OXFORDSHIRE COUNTY COUNCIL'S RESPONSE TO CONSULTATION ON THE FOLLOWING DEVELOPMENT PROPOSAL

Application no: 23/03139/REM

Proposal: Reserved Matters Application (layout, scale, appearance and landscaping) for 22/02101/OUT - 250 dwellings, public open space, landscaping and associated supporting infrastructure at Land Adjoining Withycombe Farmhouse, South of Banbury Rise, Banbury.

Response Date: 06/02/2024

Drawing No. WE102-LS-006c

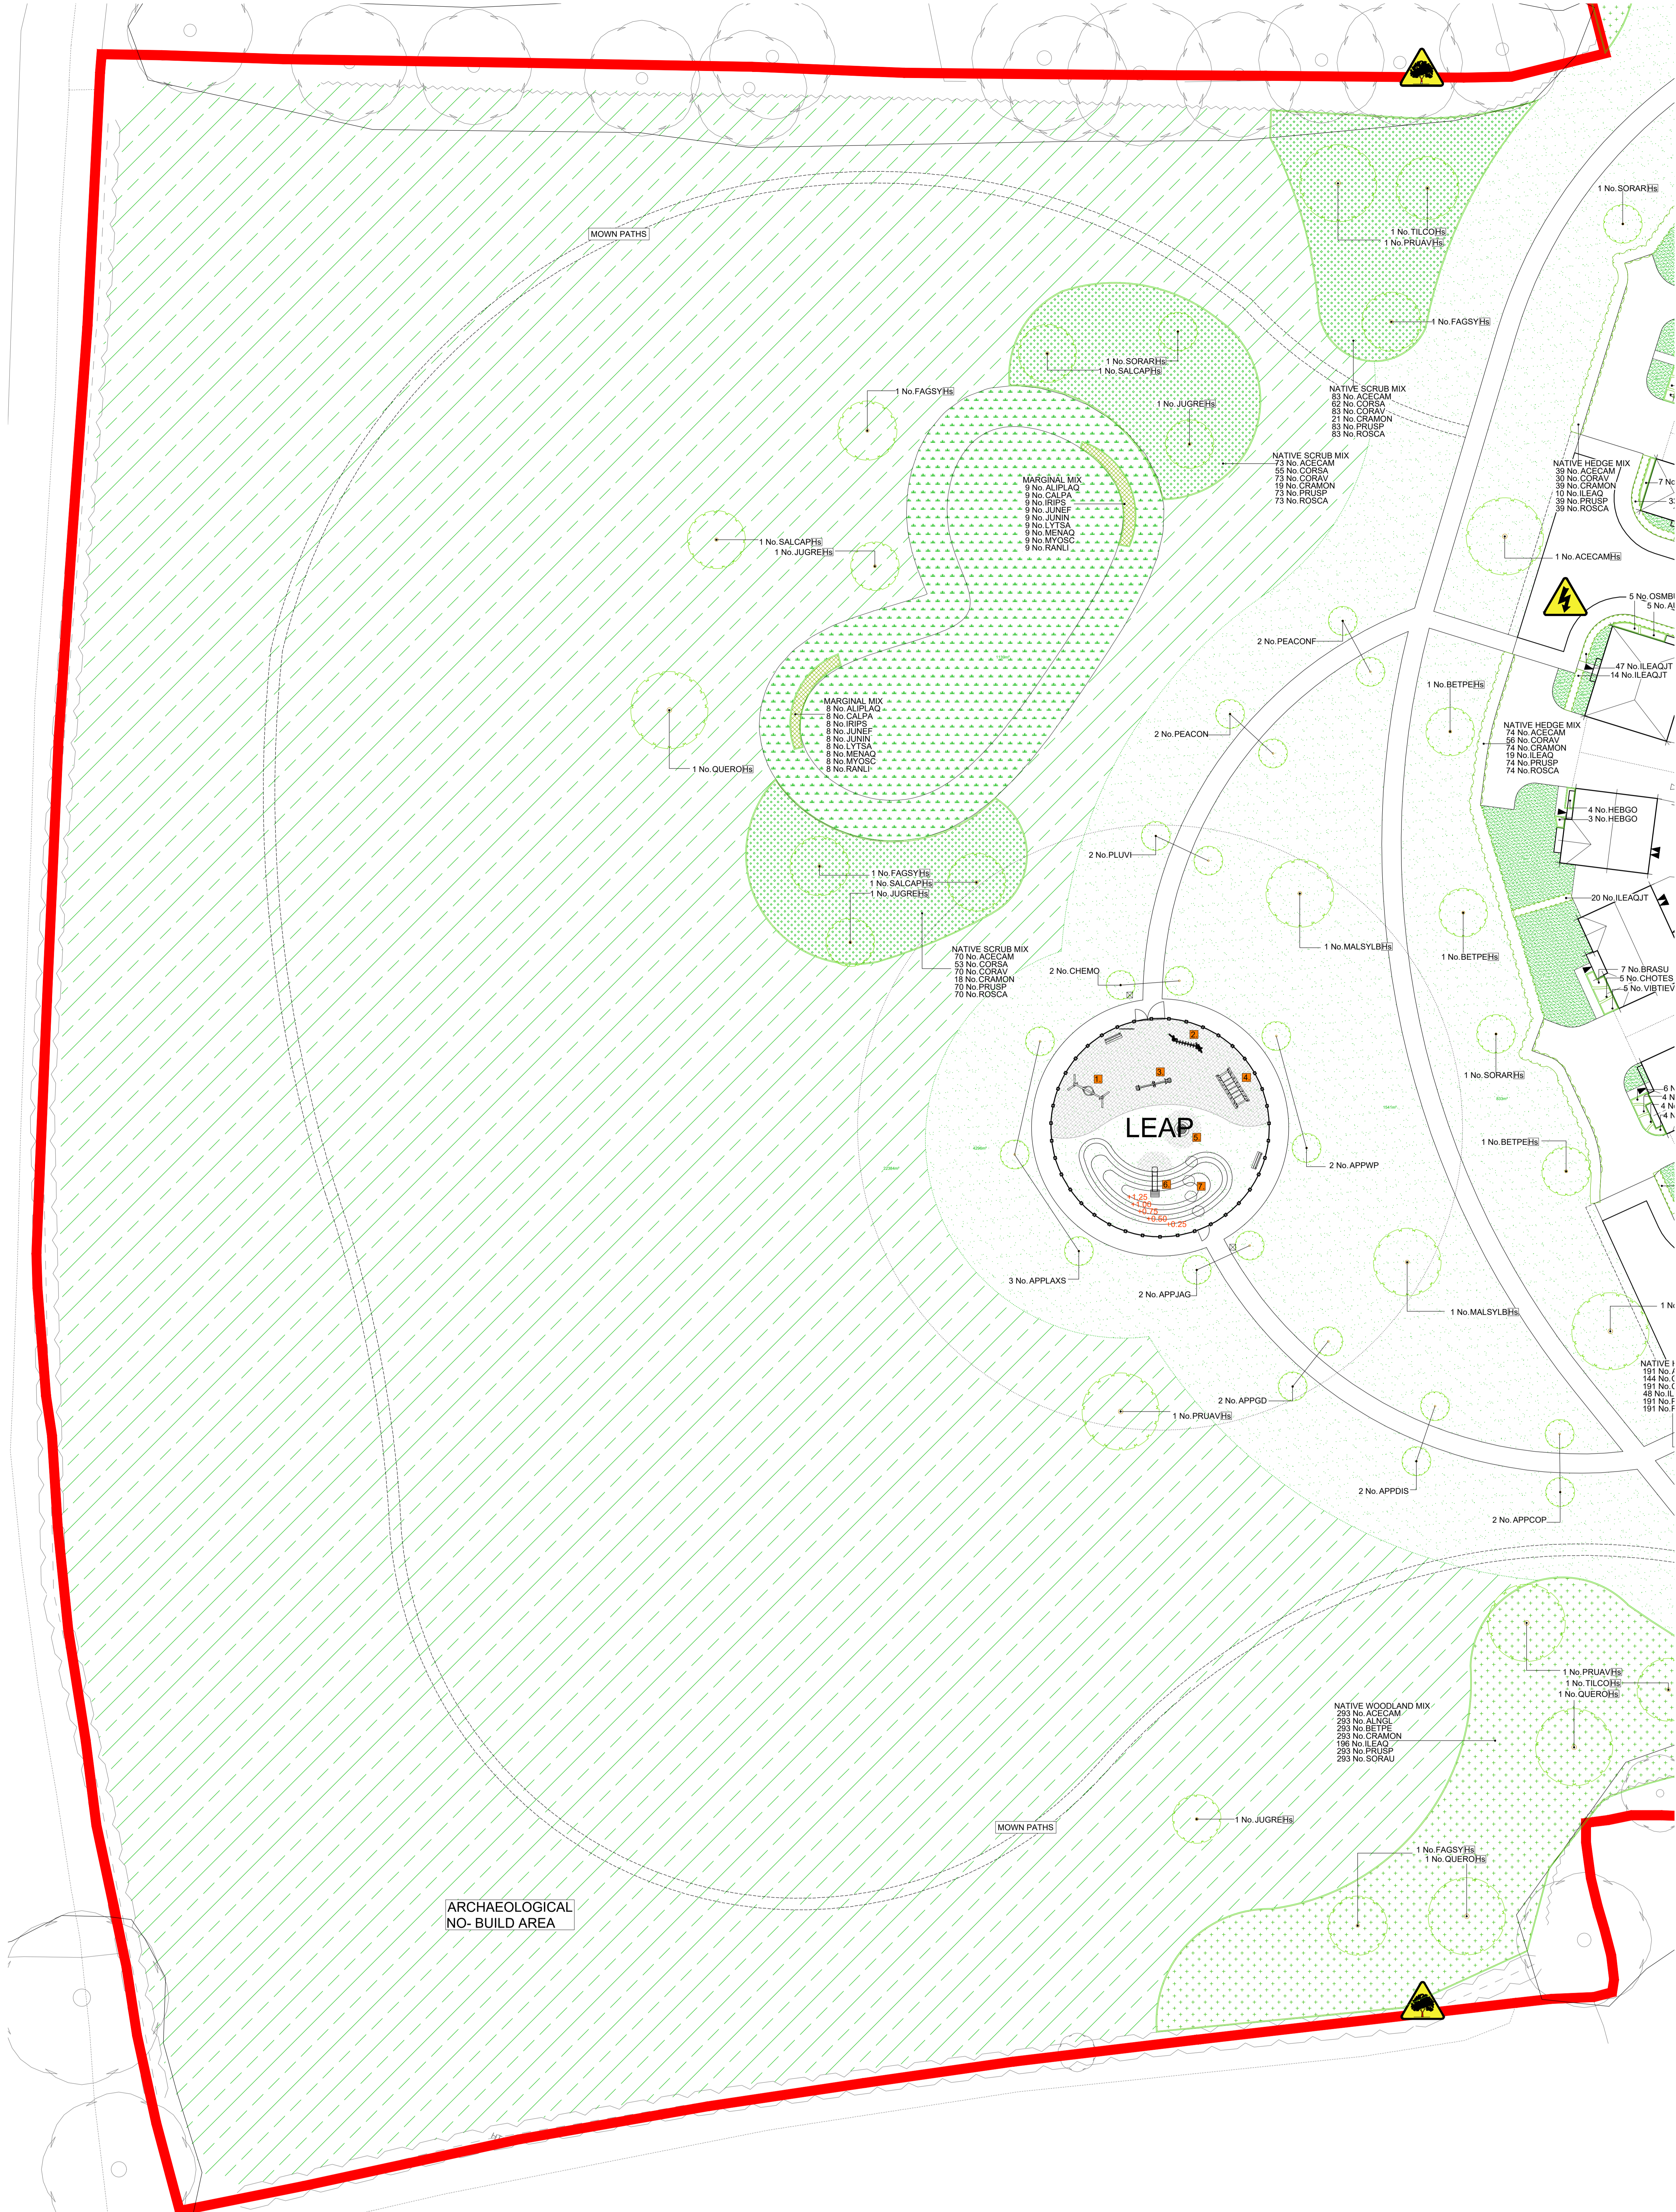
The plans submitted with this Reserved Matters application show native woodland and scrub mix planting, as well as individual trees within the agreed no build area. The plans also show paths additional to those which will be mown running through the no-build area in the northwestern part of the development. This is unacceptable under the agreed WSI, and we will require that these areas of planting are removed from the scheme.

If it is desired that the planting and paths are kept within the landscaping scheme, then a further phase of archaeological mitigation will be required in these areas. The reserved matters cannot be approved at this stage.

DRAKE

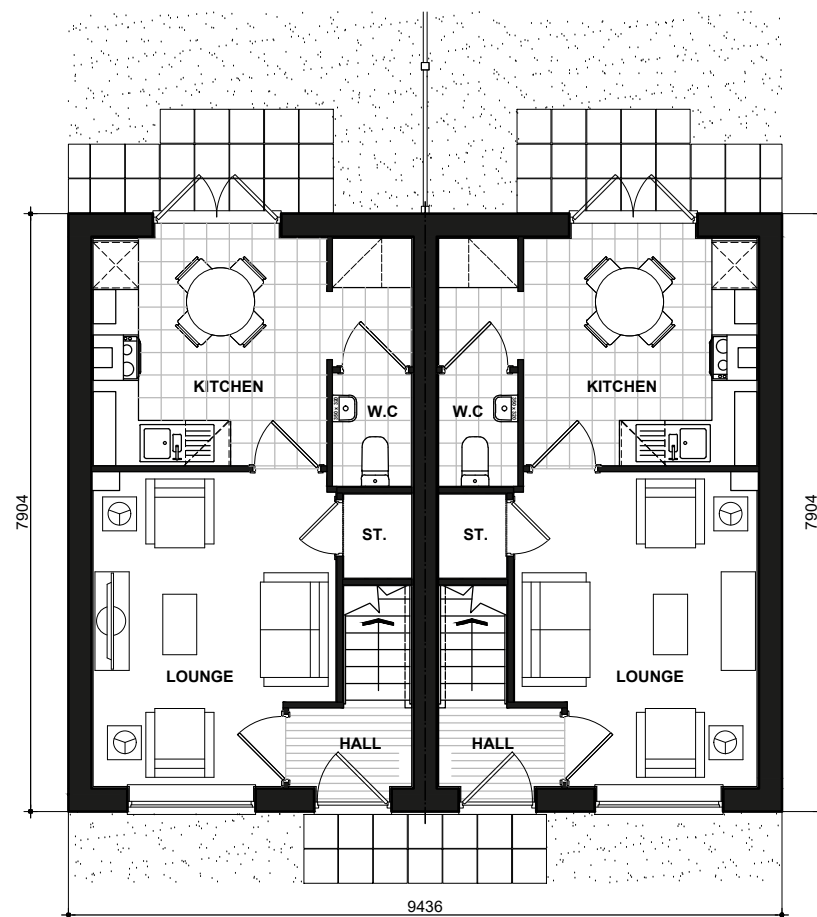
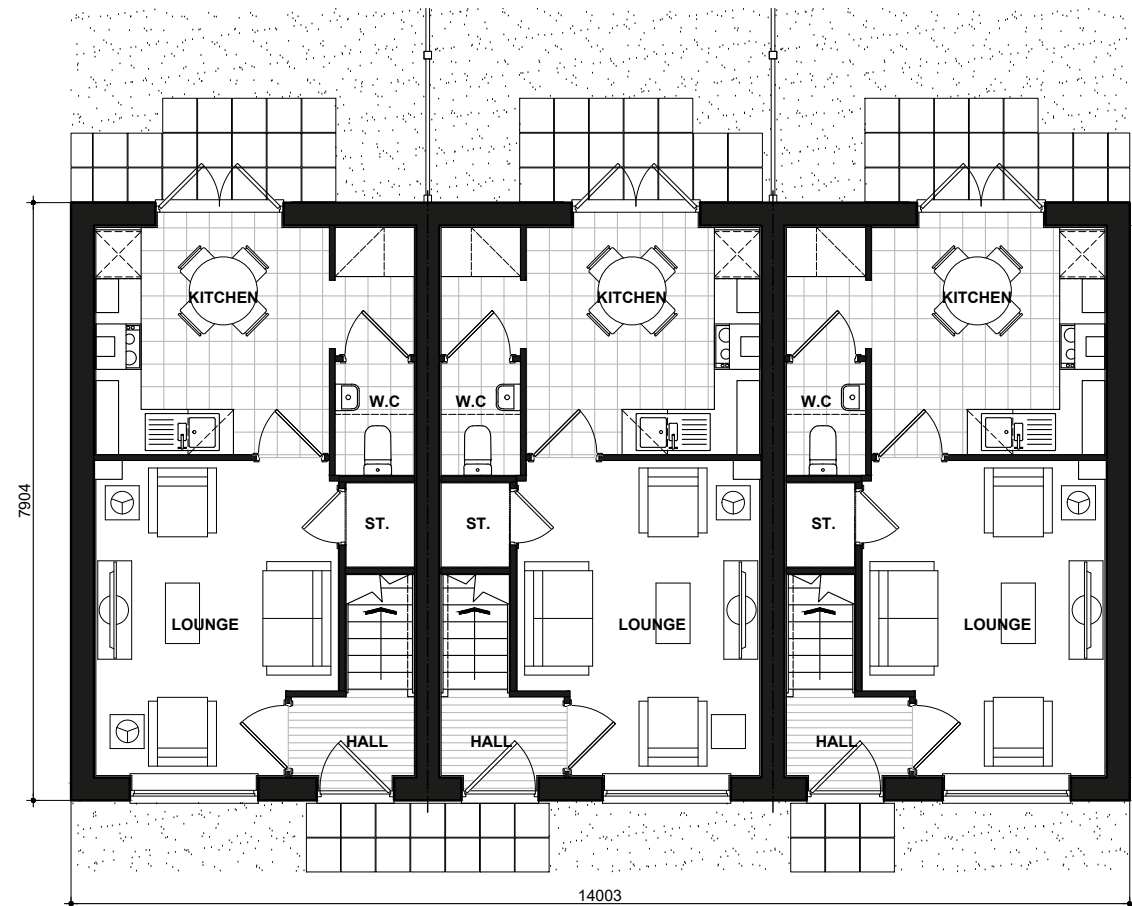
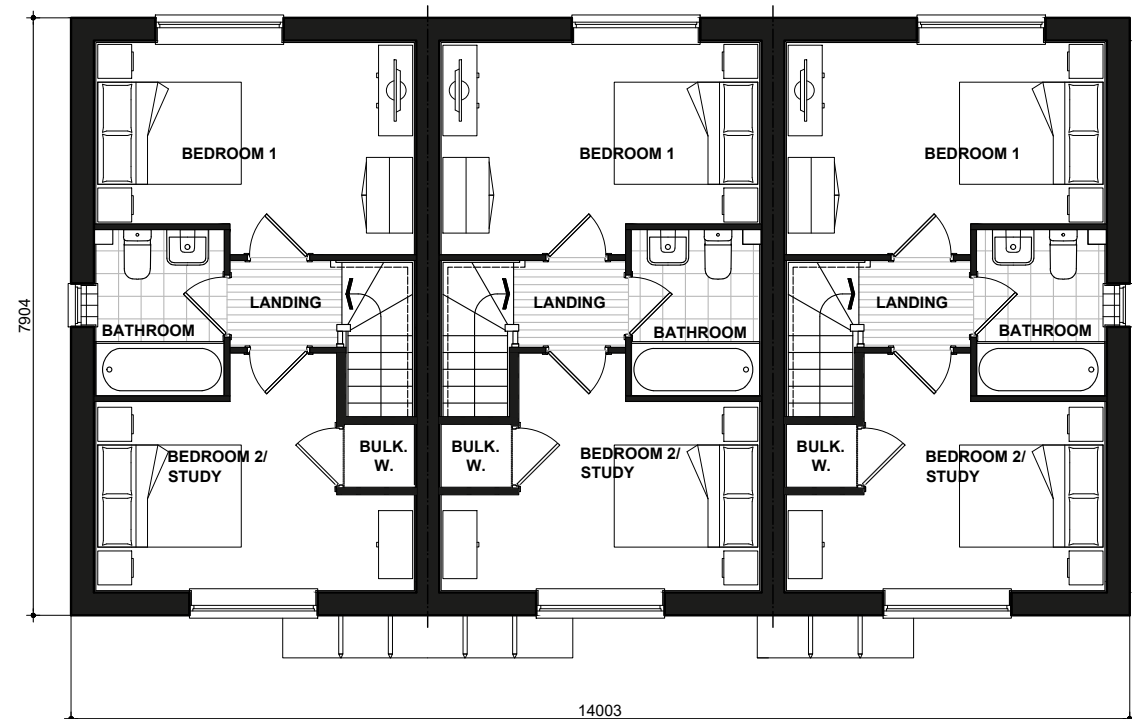
Dwelling types: Drake, Oahstone, Tiverton, Sansom, Elyot are all 2-bed houses and are currently allocated 2 vehicle spaces per dwelling, exceeding the standards listed above. The parking allocation must therefore be amended to reflect guidance.

372-1 BYRON

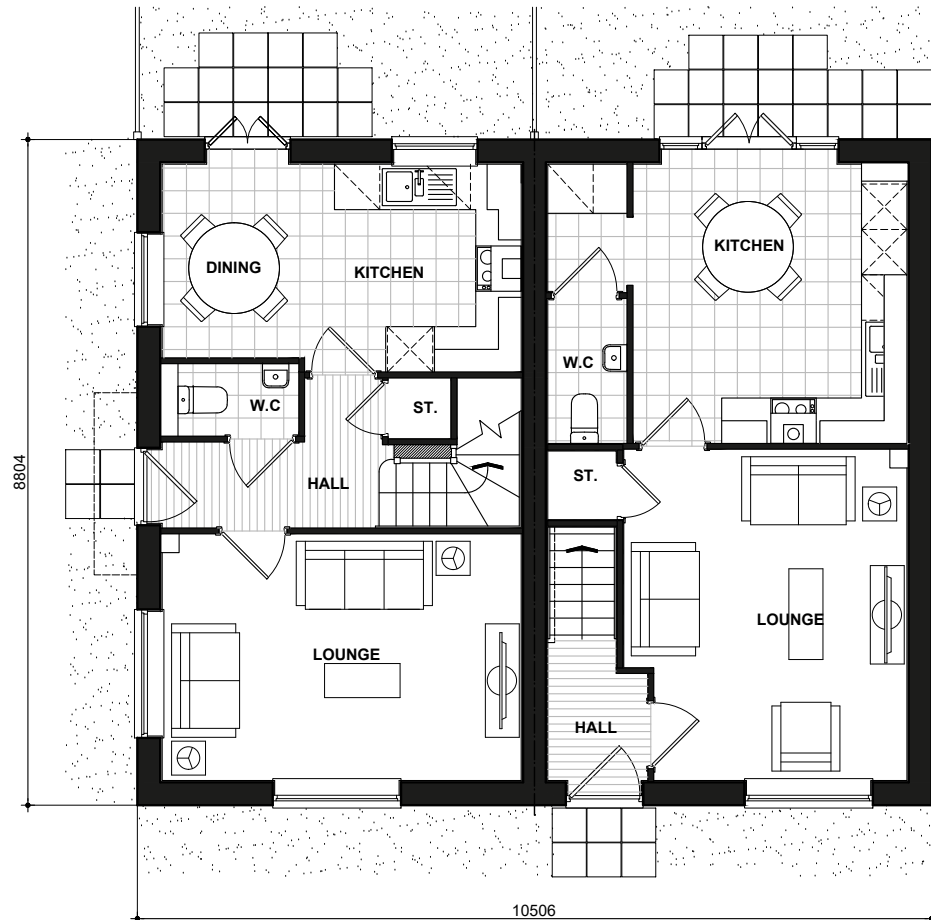
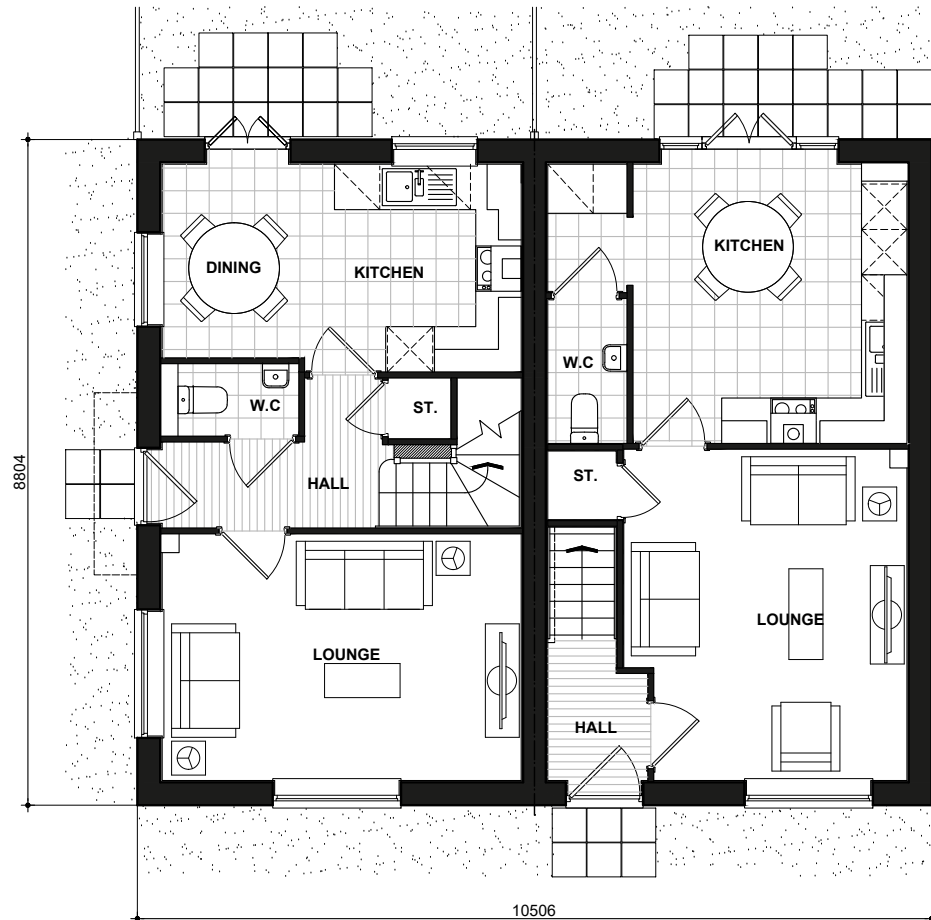
Dwelling types: Lawrence, Lyttelston, Byron, Kilburn, Henley, Wixham, Makenzie, Hallam, Locke, Hilcott, Wyatt, Wollaton, Harwood, Peele, Dawlish, are permitted to have 2 vehicle spaces per dwelling. Several dwellings within these categorisations plans have 2 vehicle parking spaces, plus a garage suitable for parking. As the OCC Street Design Guide outlines, garages (3m x 6m) must count towards parking provision, therefore amendments to parking provision must happen to make the above dwellings compliant with OCC policy.
